Mrs Louise Chater
Clerk

Arun District Planning Application P/30/19/OUT - Land North of Hook Lane, Pagham

TITLE
**PROPOSED MITIGATION WORKS
- B2166 VINNETROW ROAD**

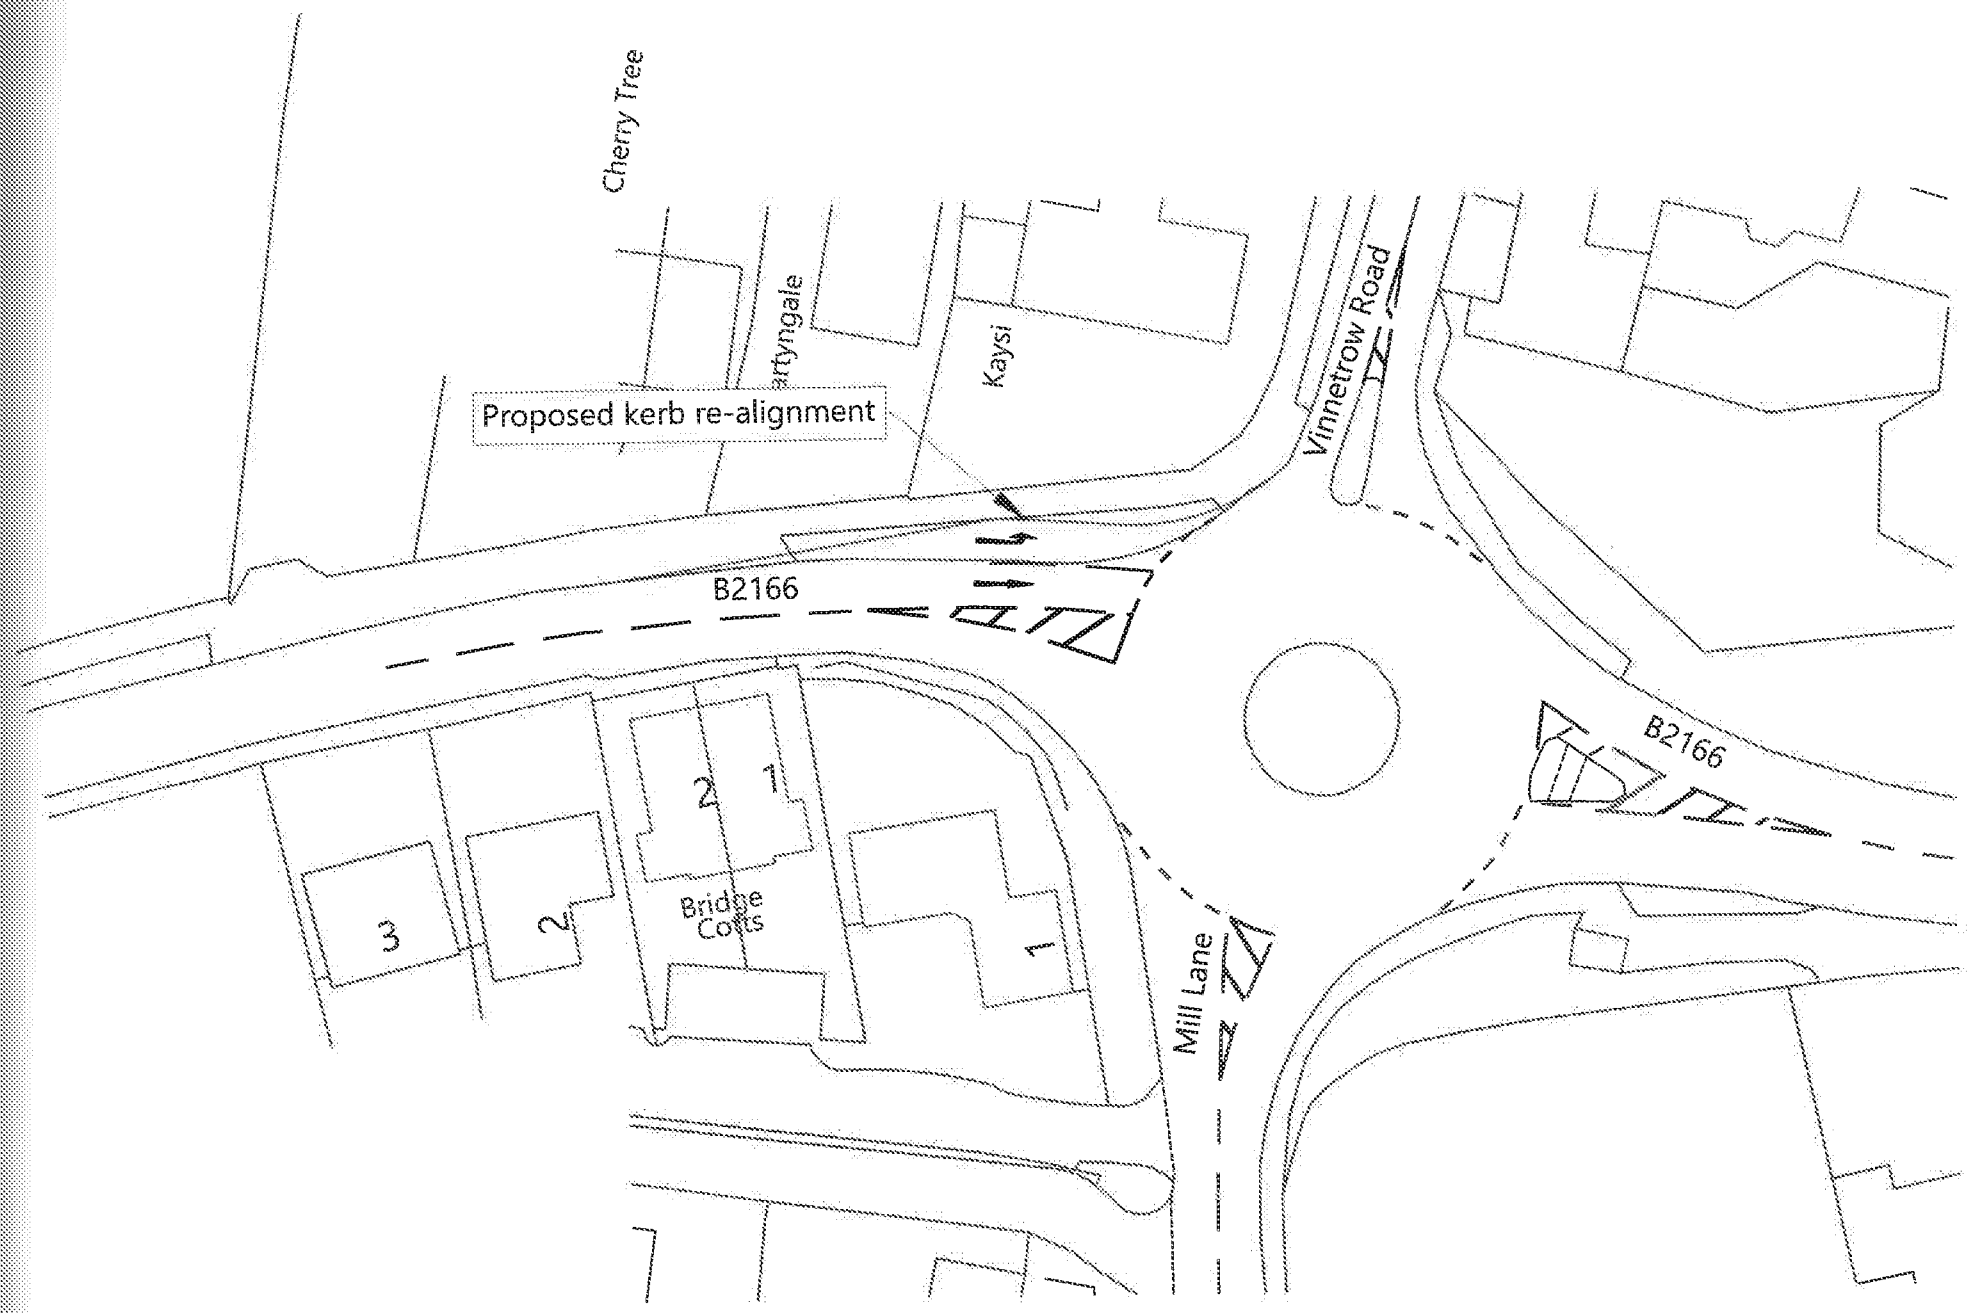
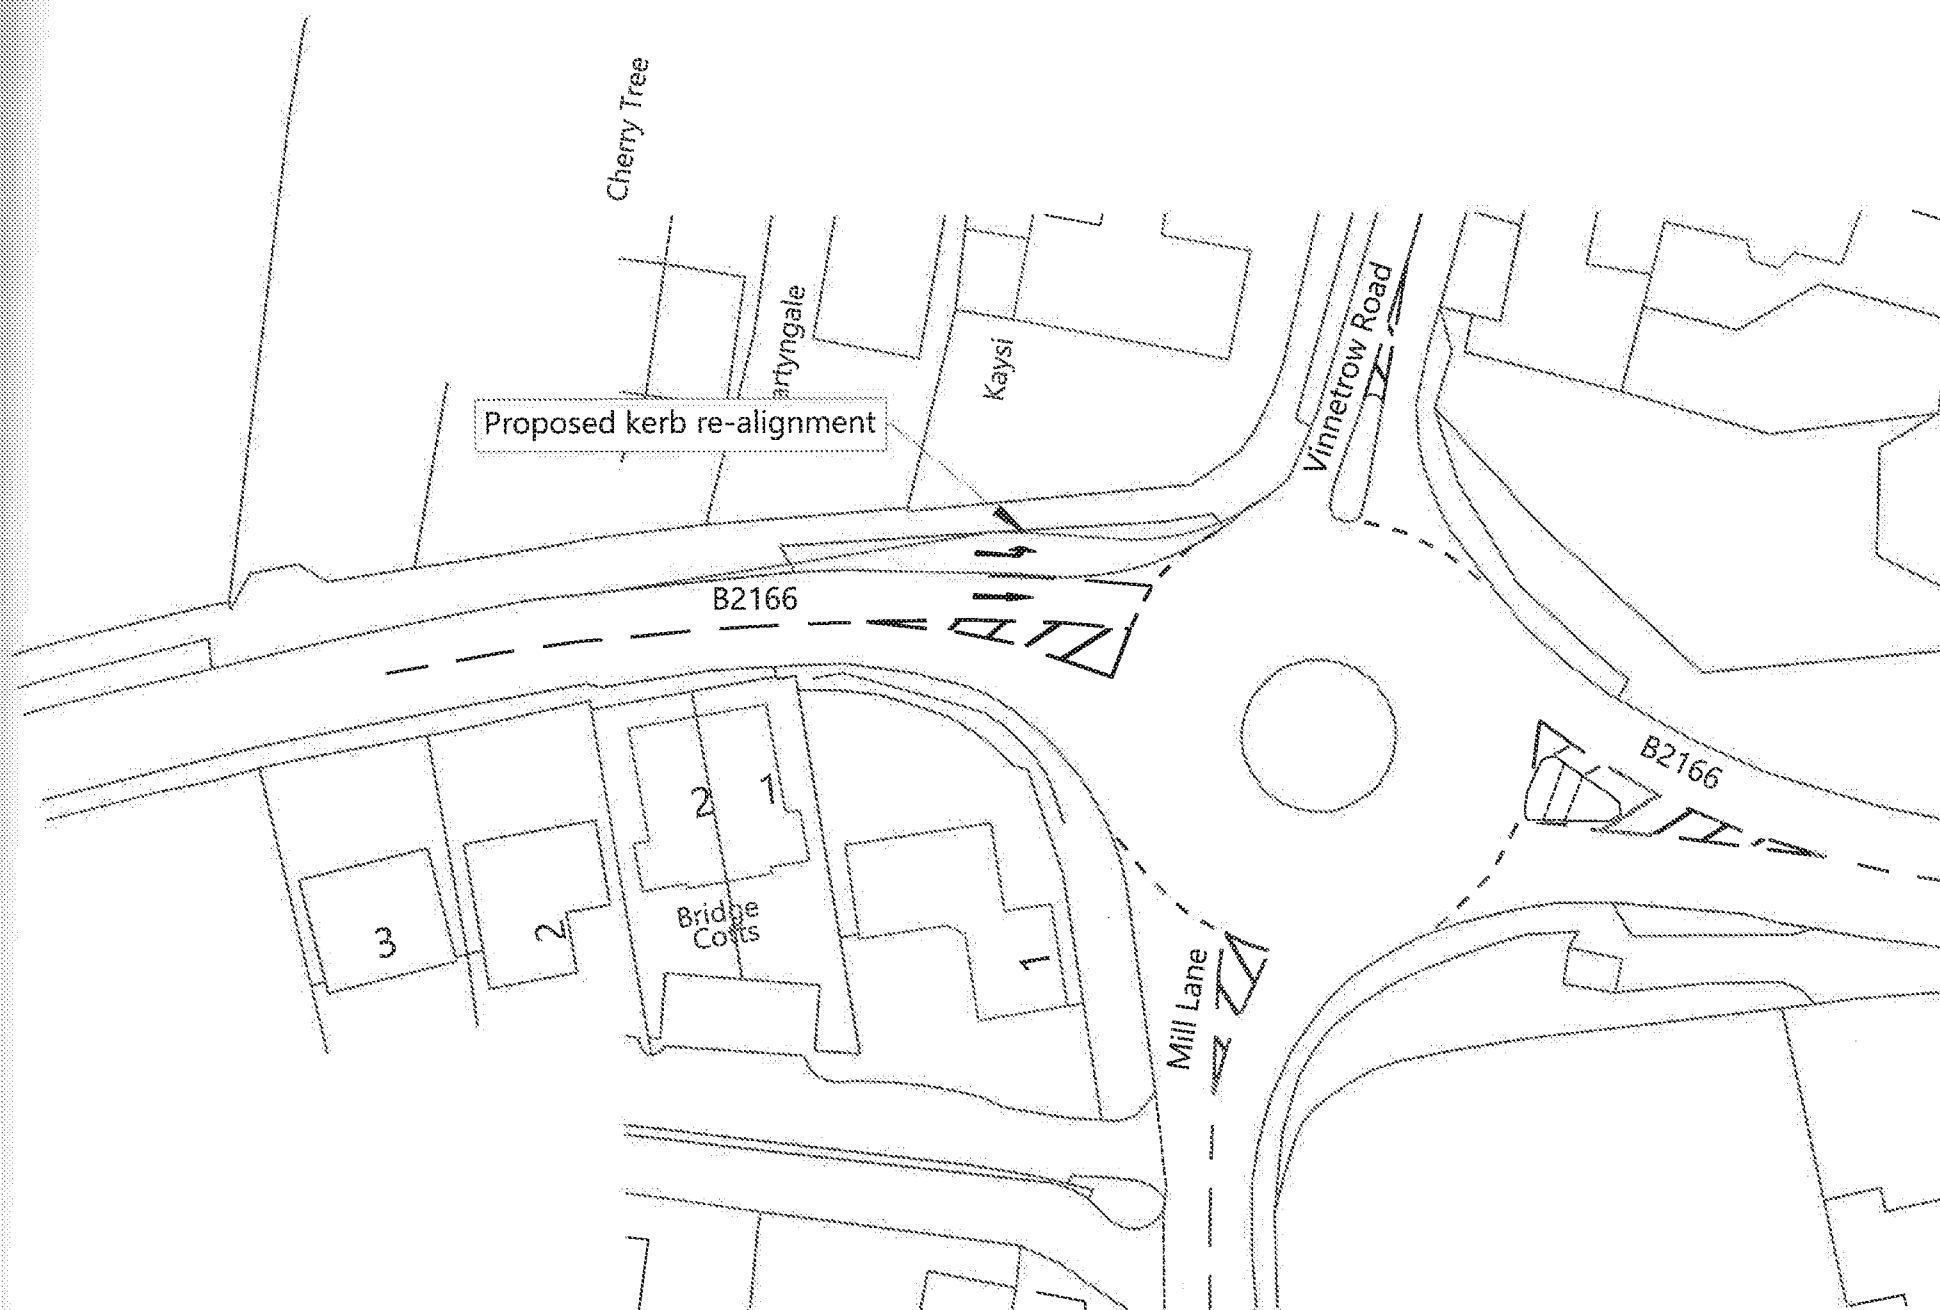
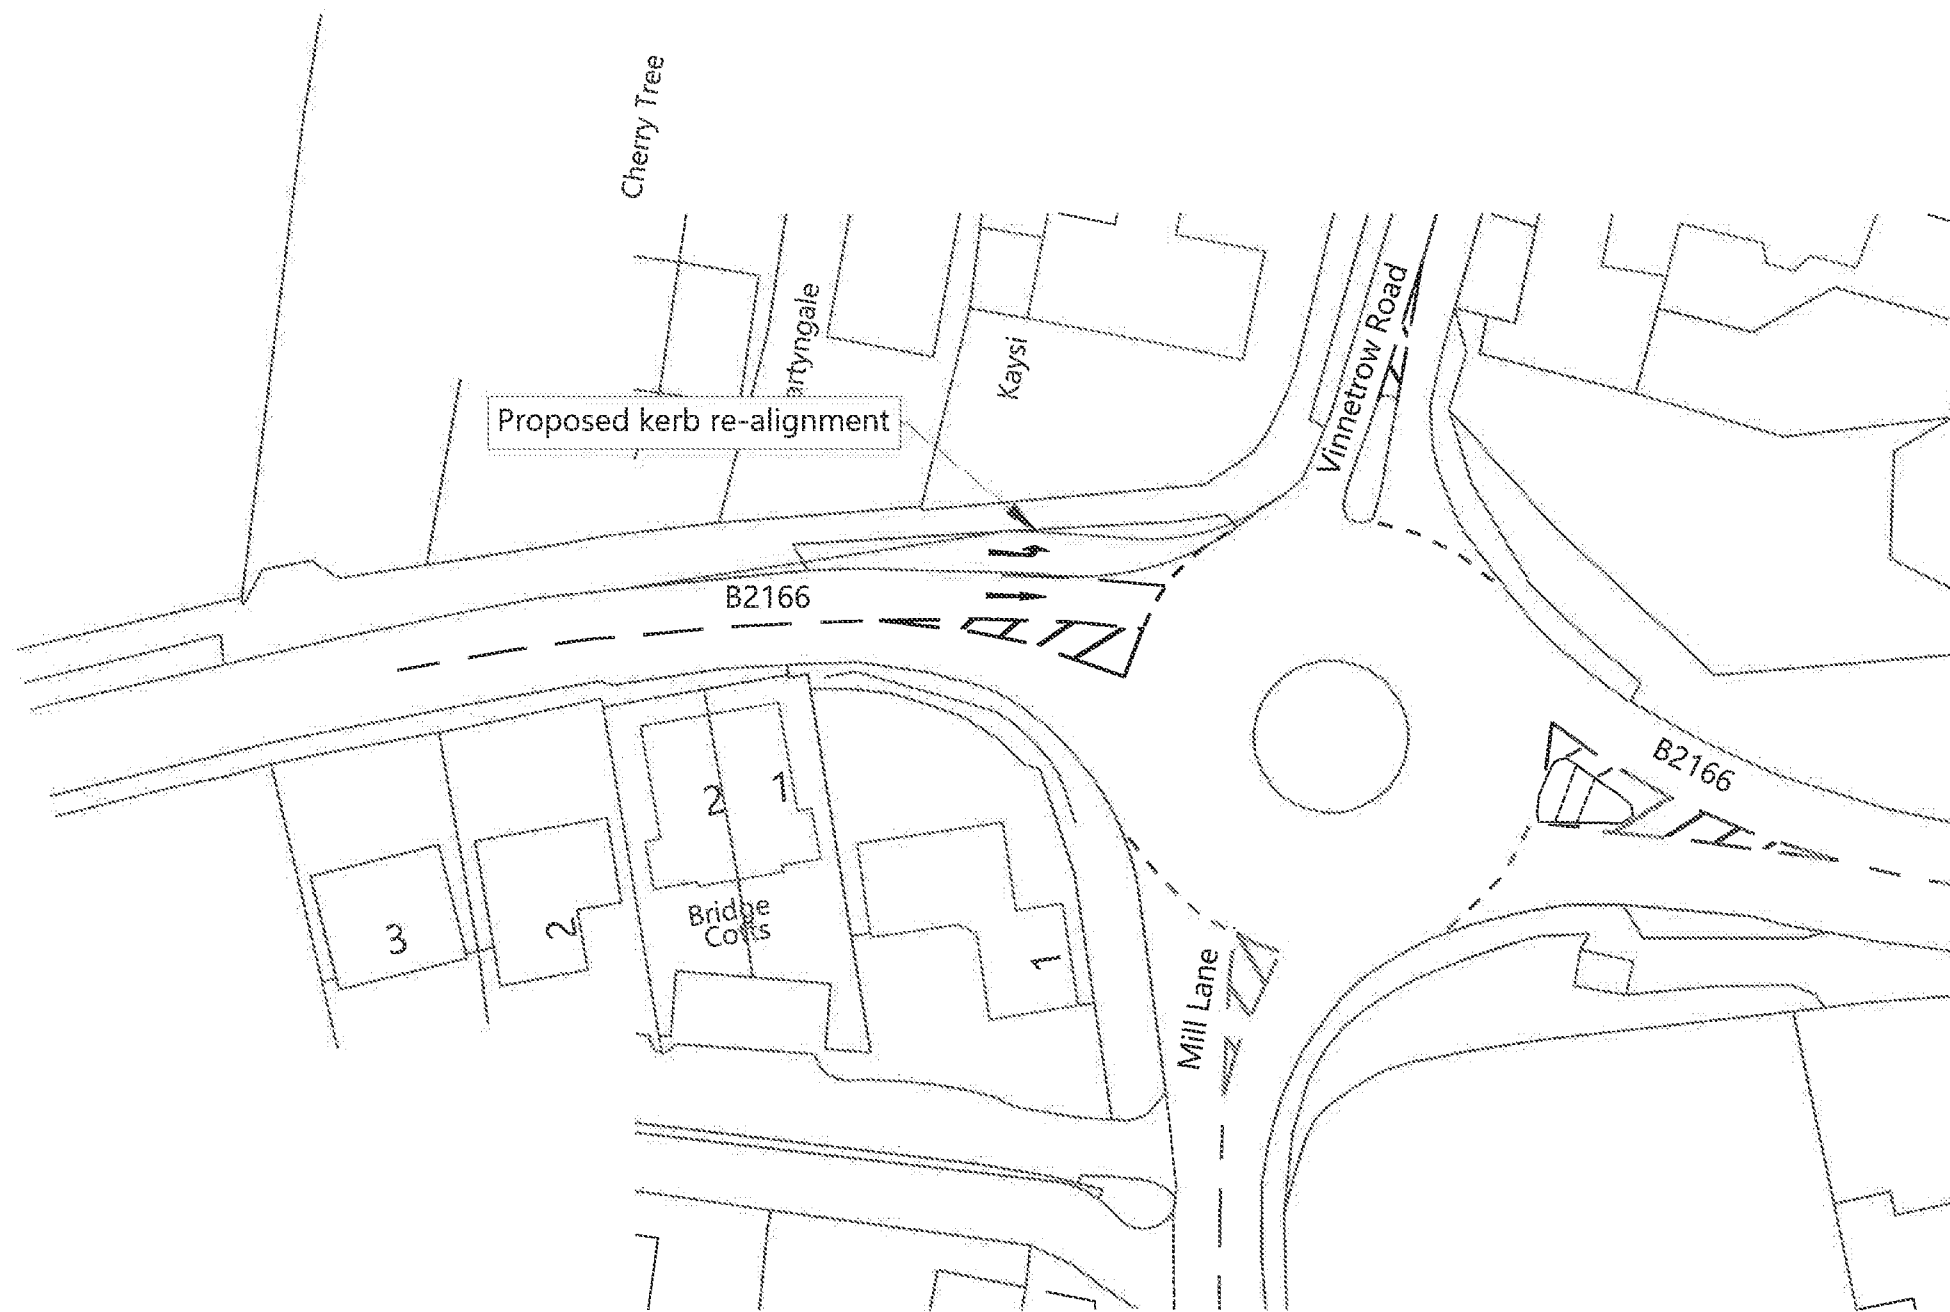
This proposed improvement to mitigate the effect of increased traffic at the Walnut Tree junction is a very short length of additional lane in the approach from the western arm of the B2166. We are not convinced this would do anything to ameliorate the traffic situation and it will do nothing for pedestrian safety. The previous work on pedestrian safety at this junction has indicated that the two lanes on the B2166 where it joins the junction from the east present a particular difficulty for pedestrians trying to cross that arm of the roundabout. We therefore have serious reservations about any proposal to add an additional approach lane on the western arm.
